PROJECT TITLE: CAUWELS & STUVE - KUNKLE RENOV.

Re: Tract B Block 8 of Mesa Village, Request for Building Permit
Engineer's Stamp dated 5-30-07 (J20/D37)

Upon review of the information provided in your submittal dated May 30, 2007, there are additional items that must be revised prior to approval for Building Permit.

DRAINAGE PLAN

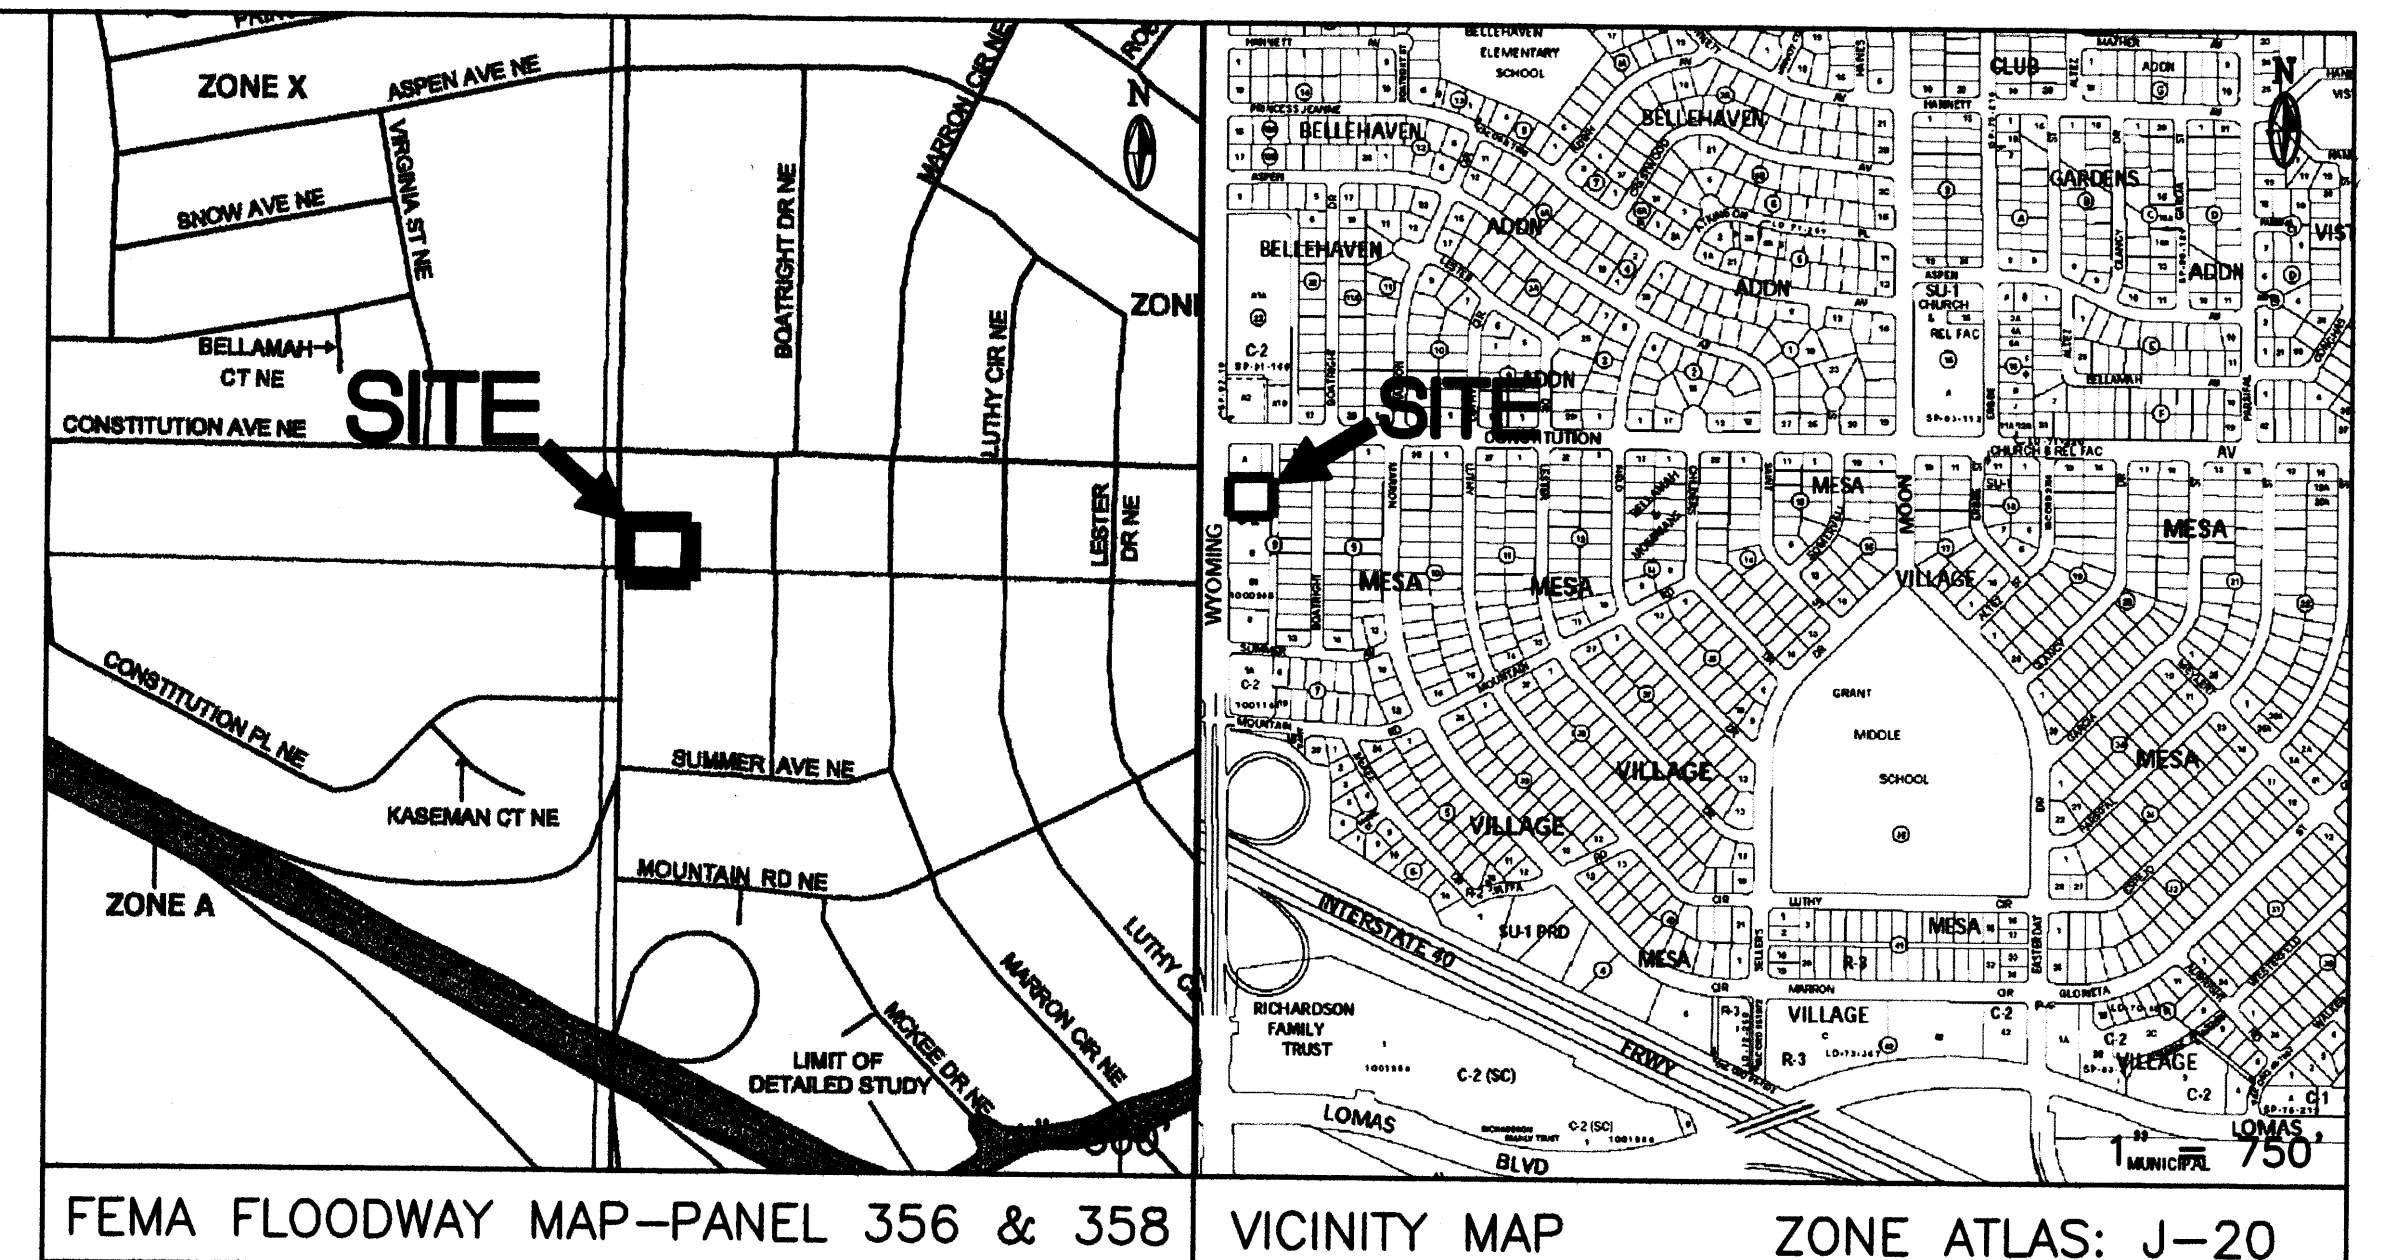
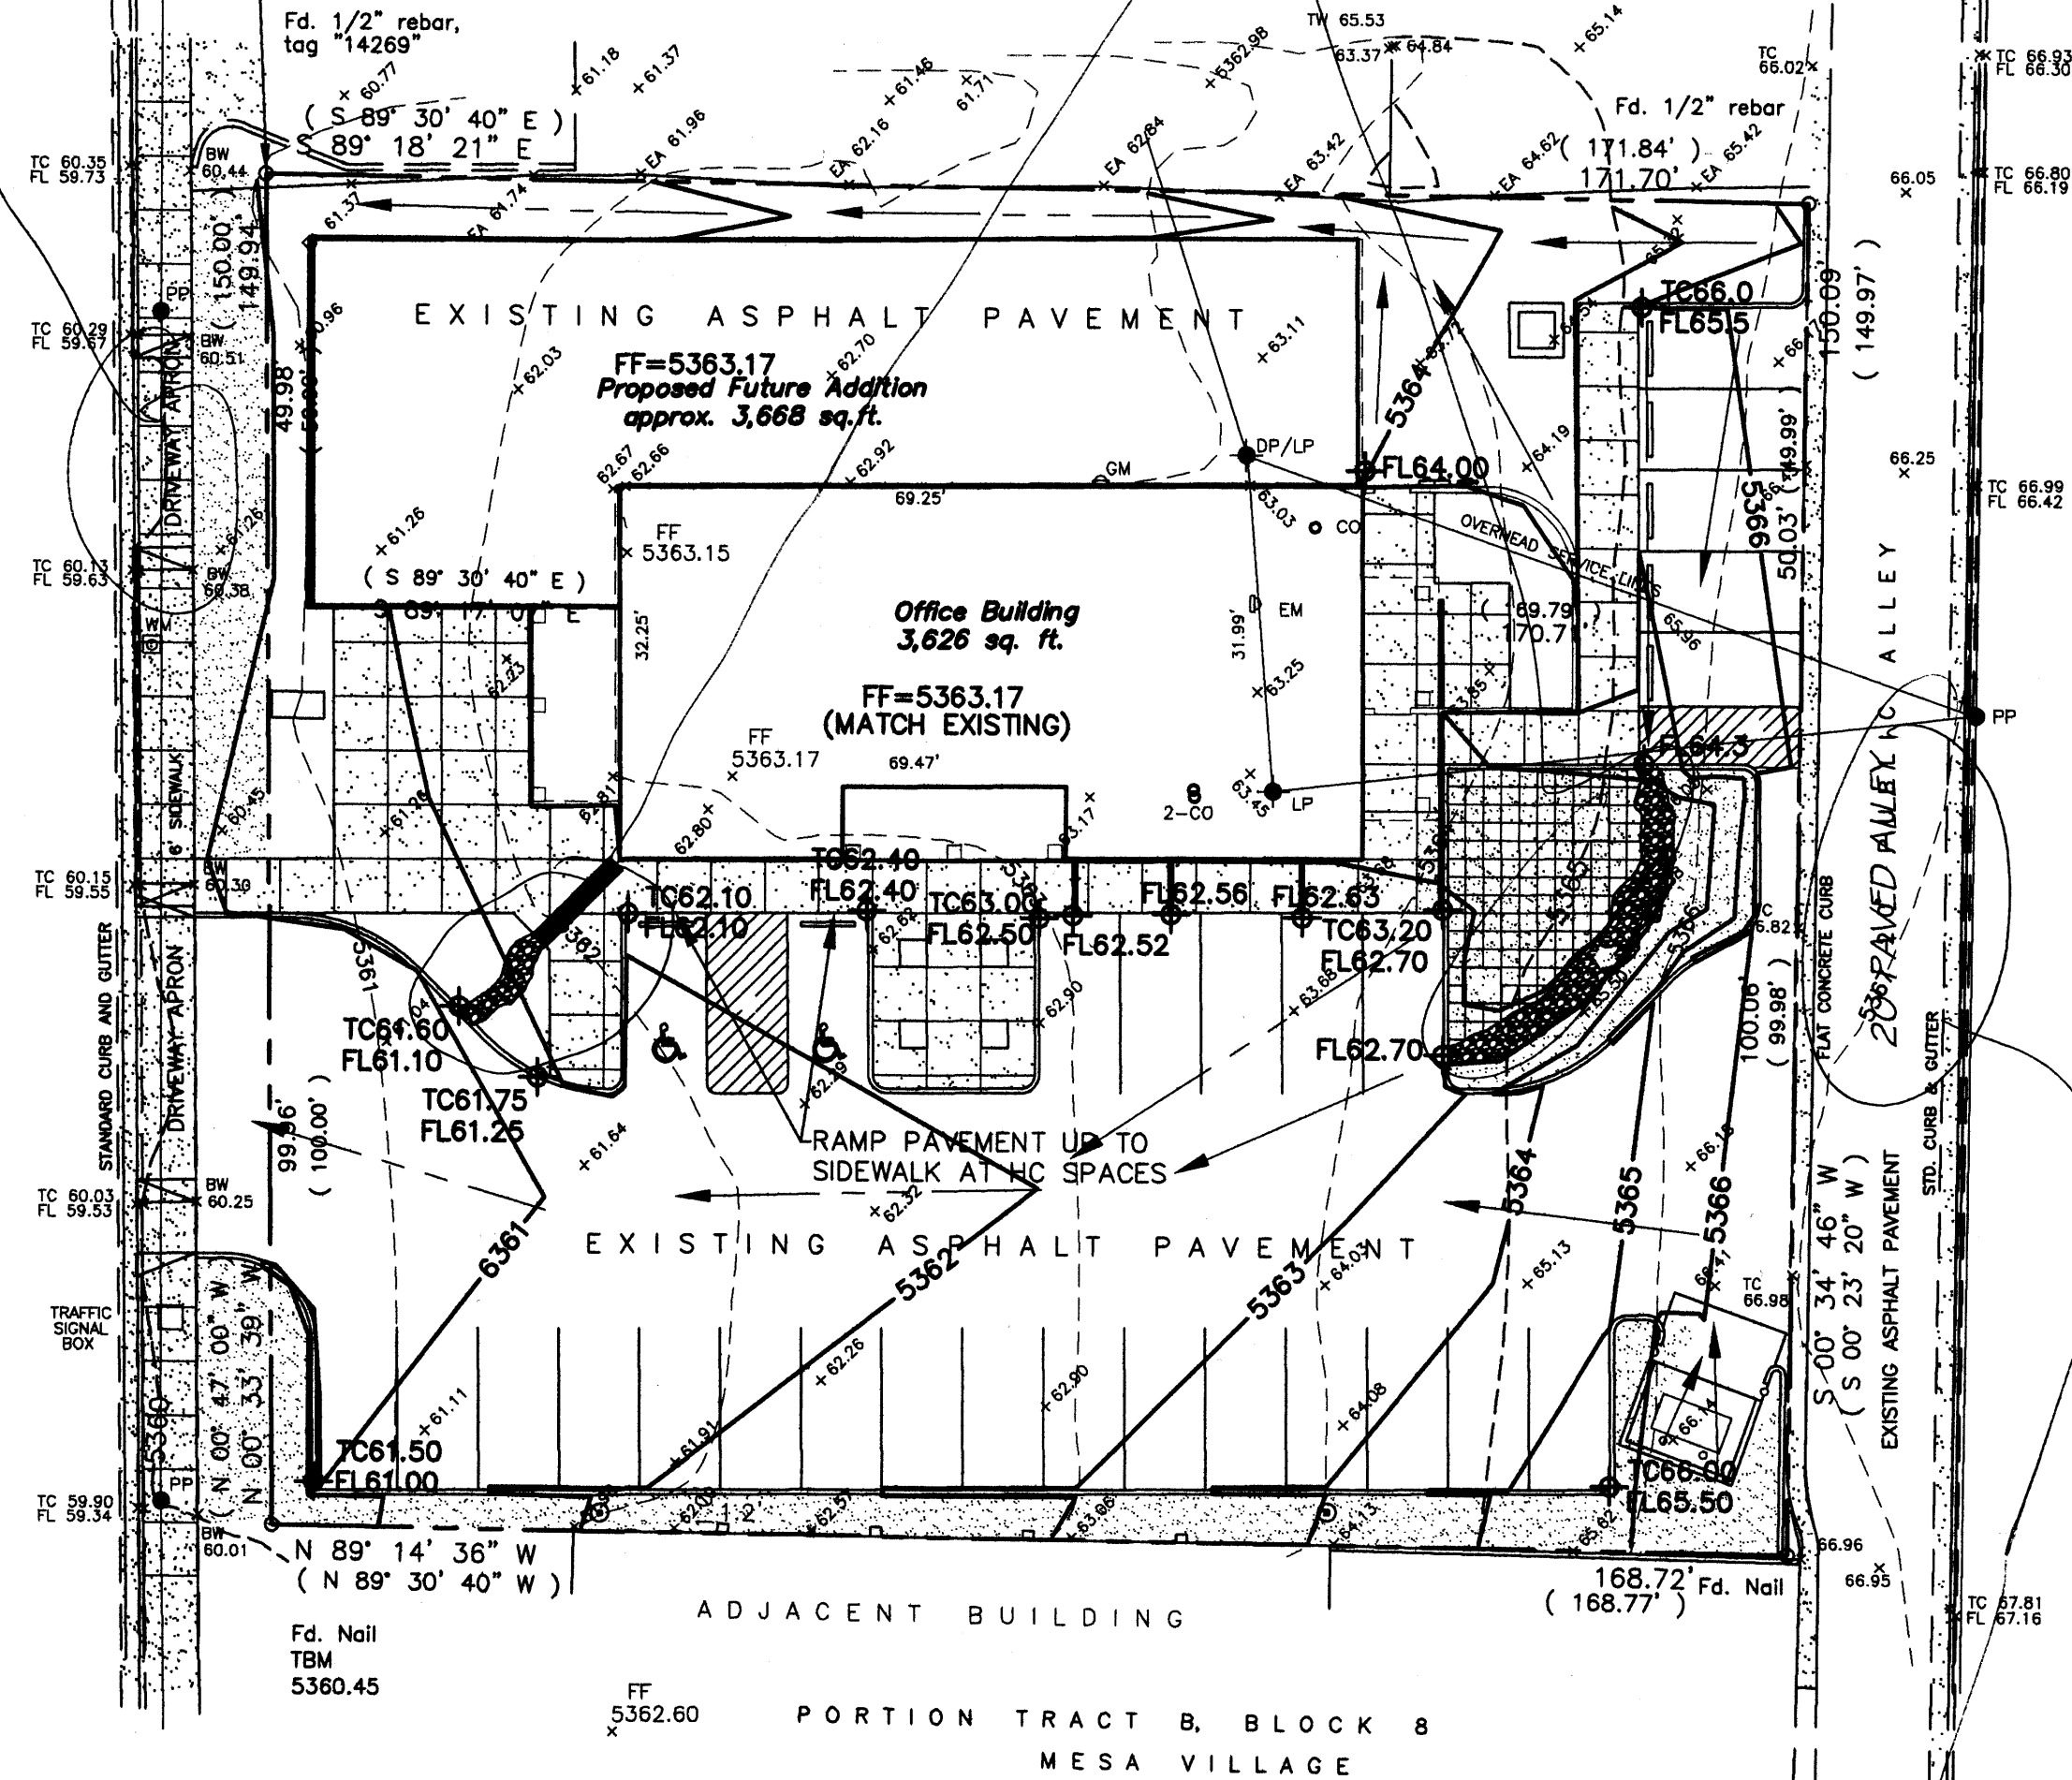
- Please relocate the overlapping text for clarity.
- Will you be closing off the northern drive entrance? If so, please reference the appropriate standard drawings.
- Your plan shows survey monument 8-J20 as being used for the grade determination but no elevation was given. Furthermore, the general notes refer to monument 11-J20.
- The FEMA maps shown on the plan (356 & 358) do not agree with the map discussed in the narrative (583). This is assumed to be a typographical error.
- Please provide a design cross-section of the two (2) proposed rip-rap rundowns.
